WOODMOOR

Water & Sanitation District No. 1

July 10, 2020

RE: Cloverleaf Subdivision – Preliminary Plan Set

SHEET 8 OF 10  
JOB NO. 25158.01

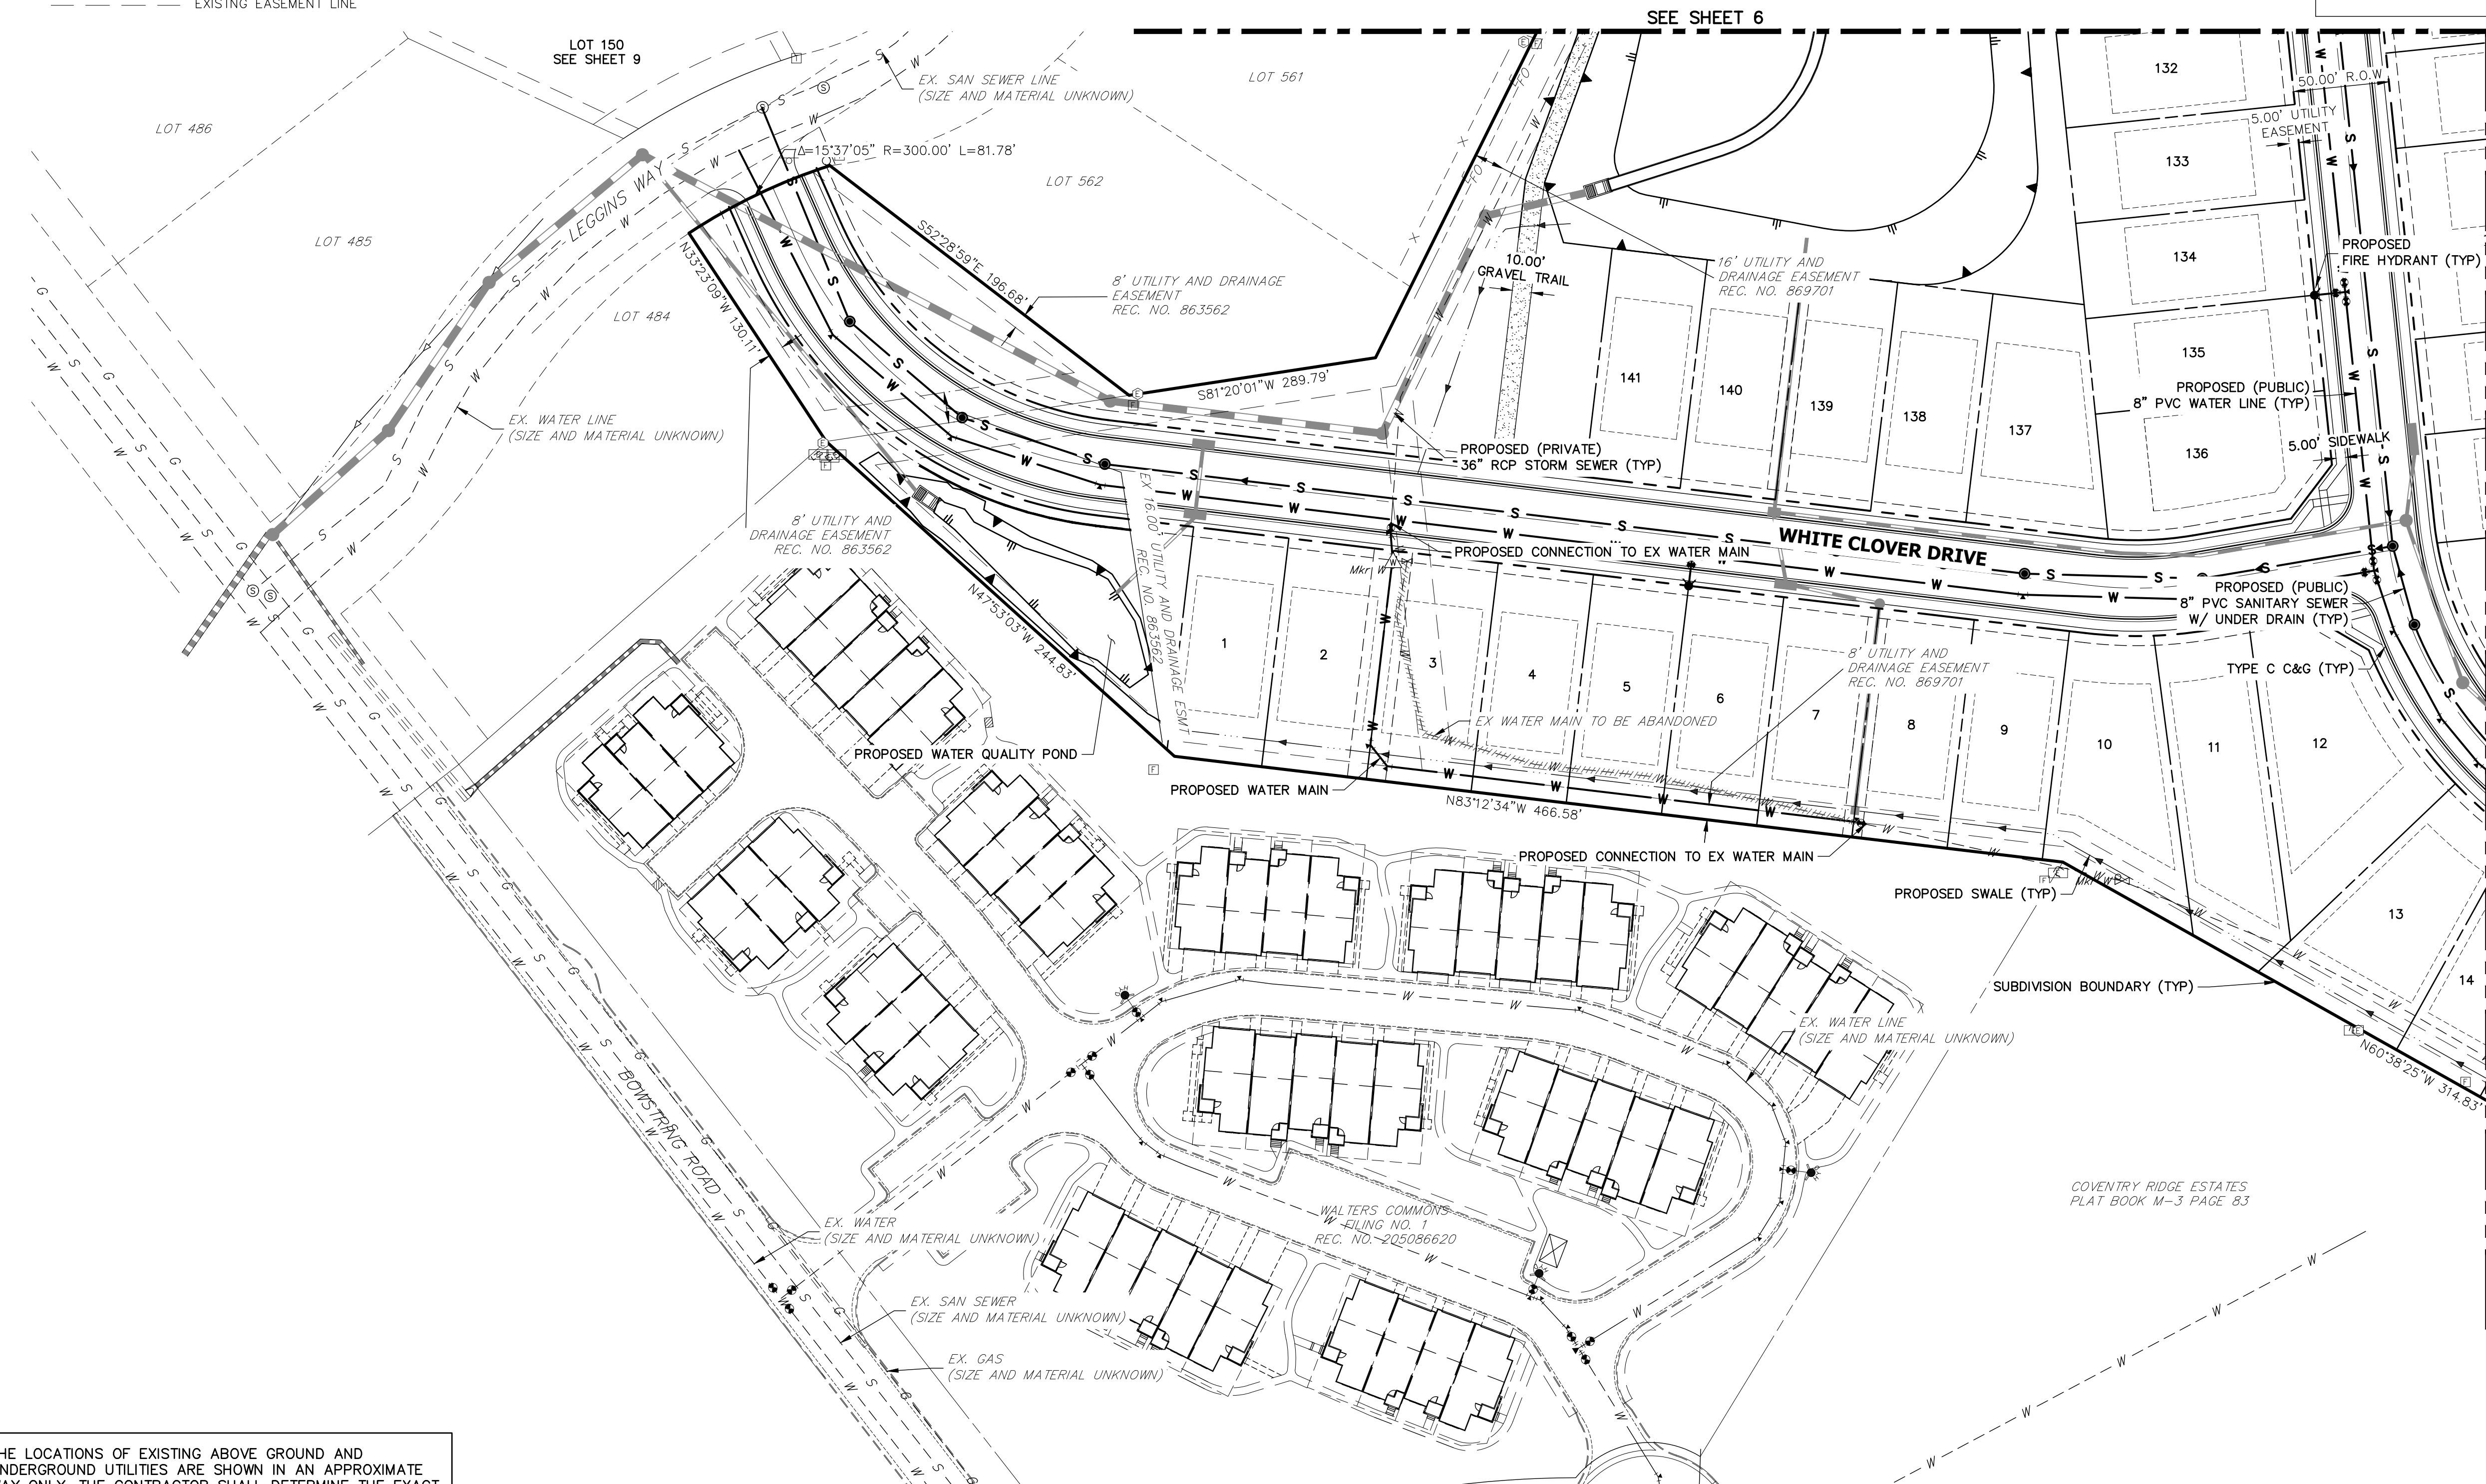
1. On Crimson Clover Drive, there is an abundance of manholes around the curve. By straightening the pipeline in sections such that the pipeline does not align with the curvature of the road, it will be possible to decrease the number of bends, and therefore the number of manholes. Is this possible, while maintaining clearances from other utilities and remaining within the right-of-way?

2. Move text labels to ensure all appurtenances are visible.
3. The water pipelines cannot be “dead end” lines. Please attach the end of the proposed water pipeline to an existing distribution pipeline, located either in Caribou Drive or Walters point. Add three (3) isolation valves at tie-in point. Add easement, 10 feet from center of pipe, as required.

4. In Walters Point, the sanitary sewer pipeline cannot bend or curve. Please add a manhole at each necessary bend between tie-in point and manhole in front of lot 147.
